Our reference: ECM: 8723857
Contact: Paul Anzellotti
Telephone: (02) 4732 8606

Department of Planning & Environment
Attn: Jess Fountain
DA Coordinator
Key Sites and Industry Assessments
GPO BOX 39
SYDNEY NSW 2001

Notice of Exhibition – Kemps Creek Warehouse, Logistics and Industrial Facilities Hub (SSD 9522) at 657 – 769 Mamre Road, Kemps Creek

DRAWING NUMBER ISSUE
SP-KC1-DA-003 I

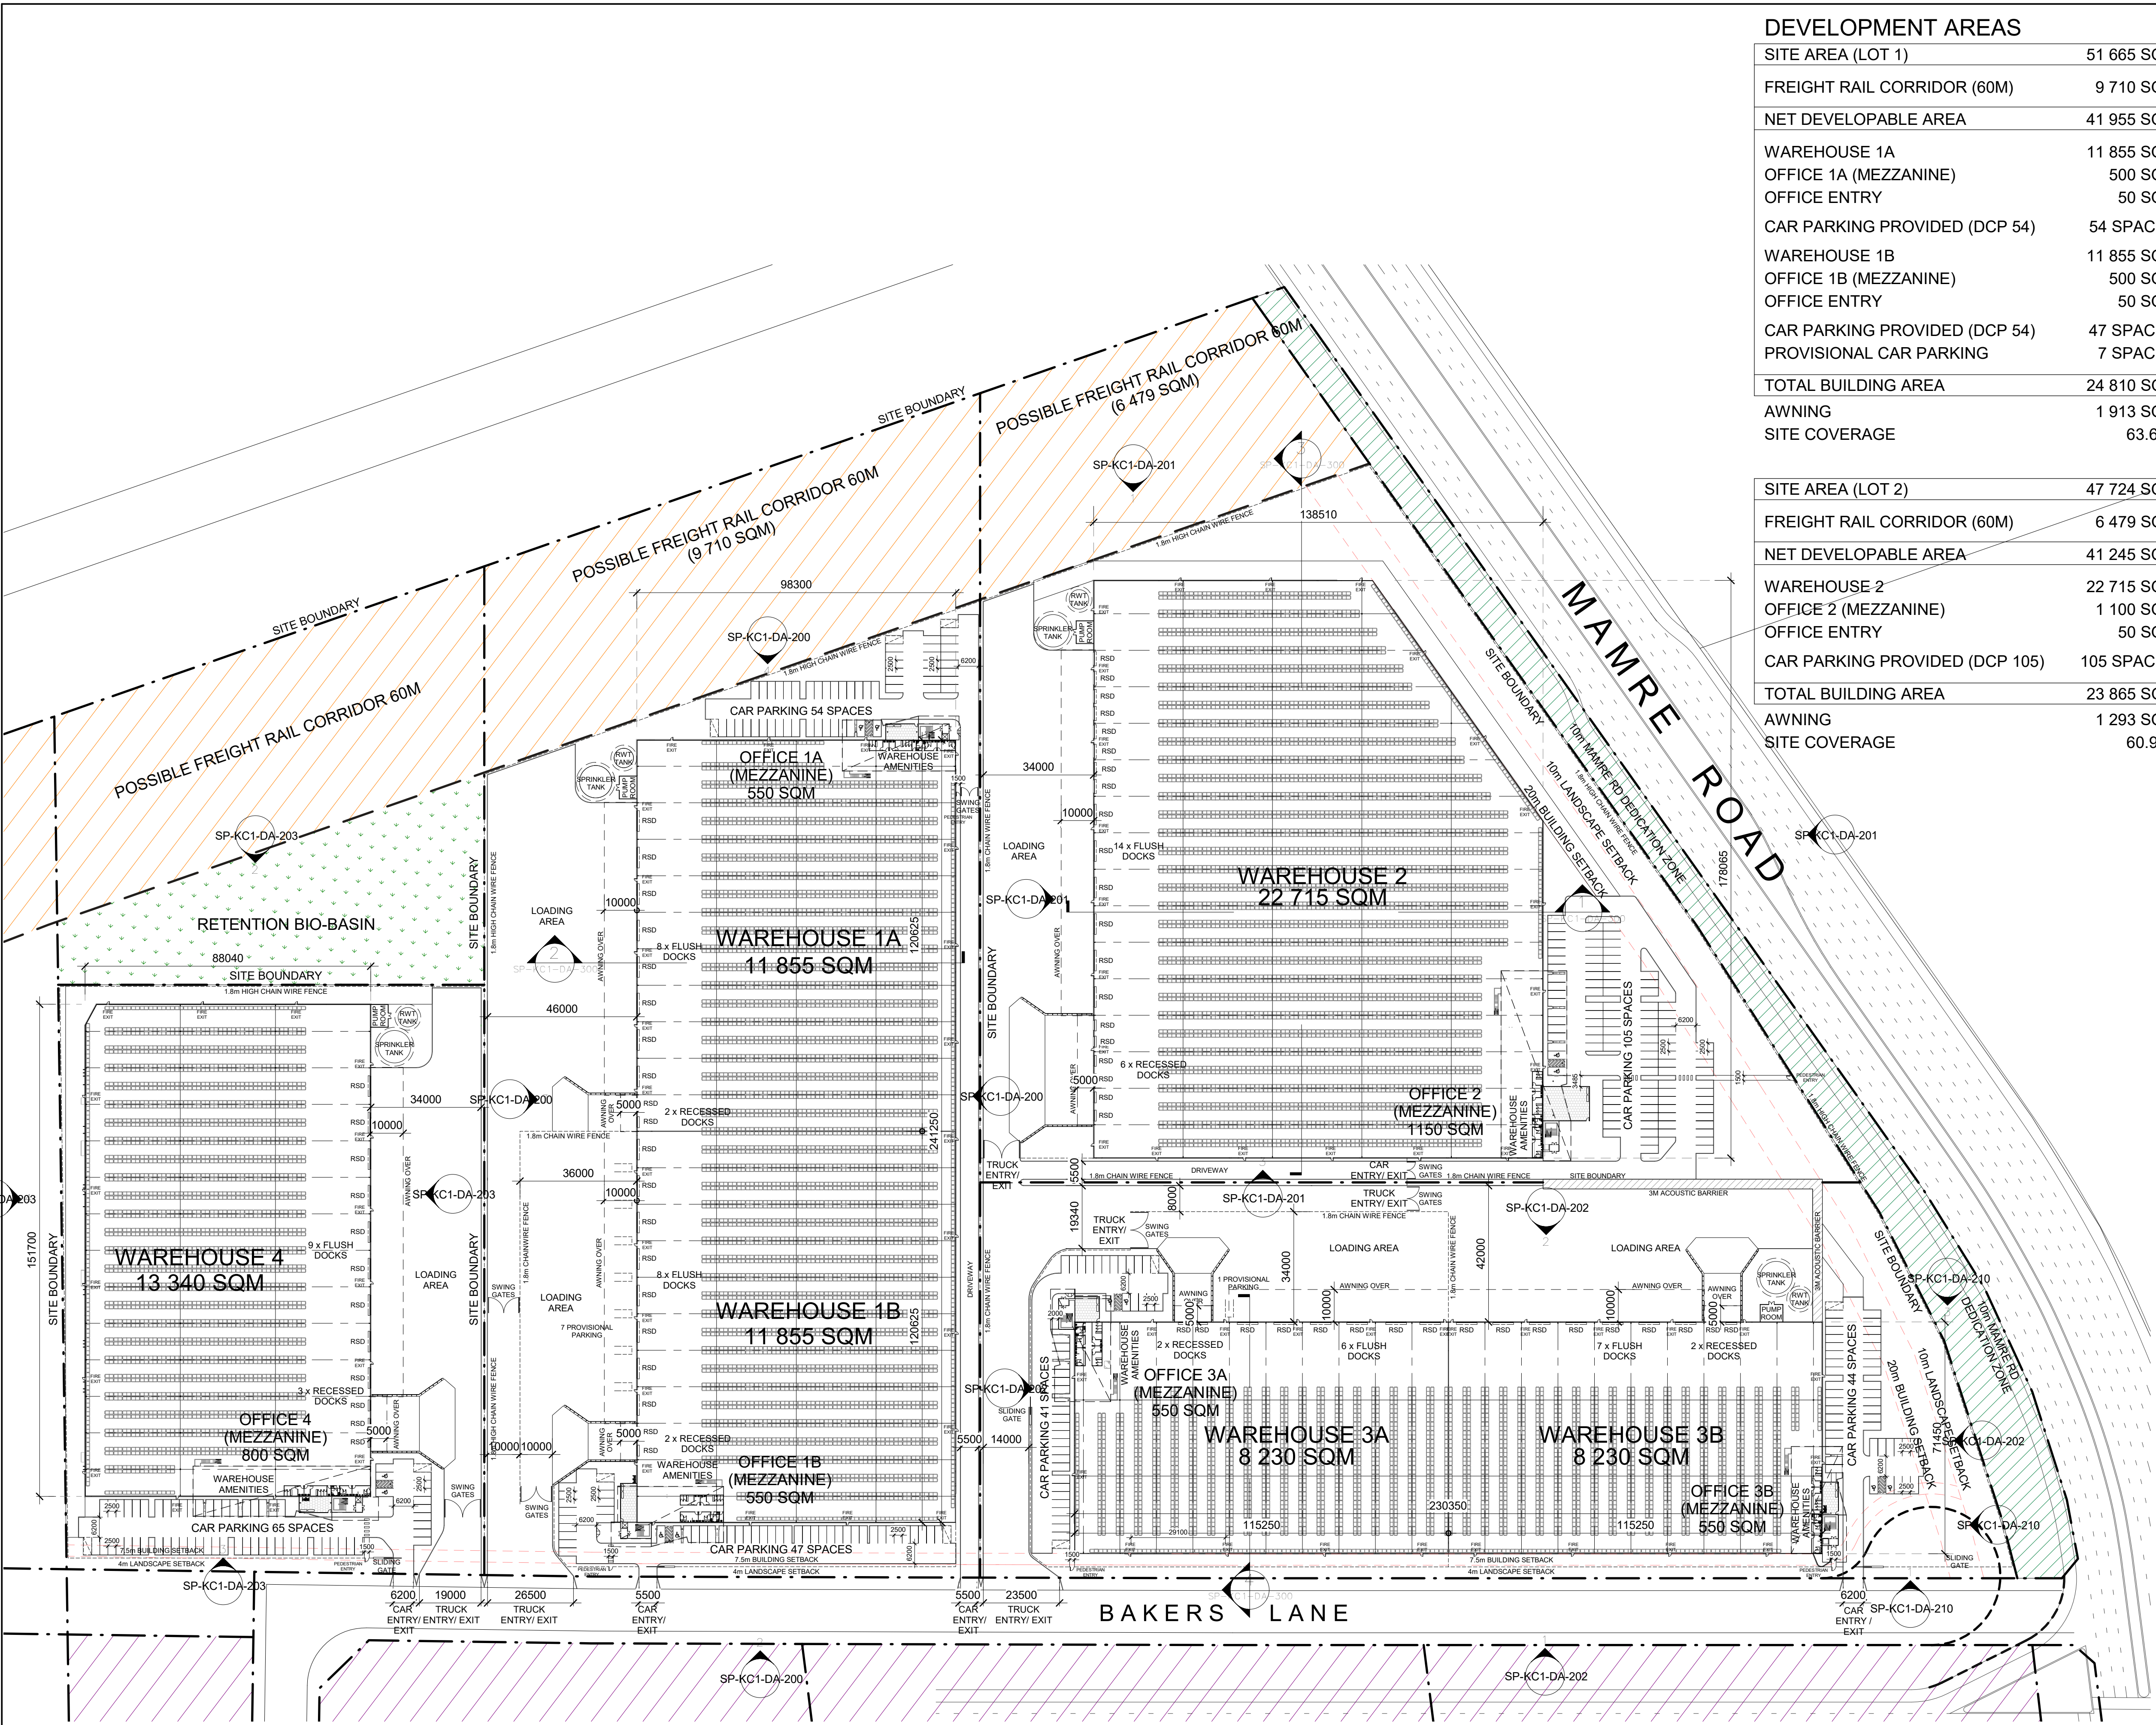
- **Freight Line Corridor**
The Drawing SP-KC1-DA-003 identifies the future Western Sydney Freight Line as a 60m corridor. However, TfNSW’s letter dated 6 September states that the corridor 60-80m. This requires confirmation from TfNSW prior to the approval.
- **Road Classification**
Road Classification for the future Southern Link Road (SLR) extension should be State Road, not a Local Road.
- **Interim Access Scenario**
Currently the timing of the delivery of SLR from the State Government is unknown. Therefore, the applicant has proposed to convert the existing “T” signalised intersection at Bakers Lane/Mamre Road to a “four-way” signalised interim access to the development.
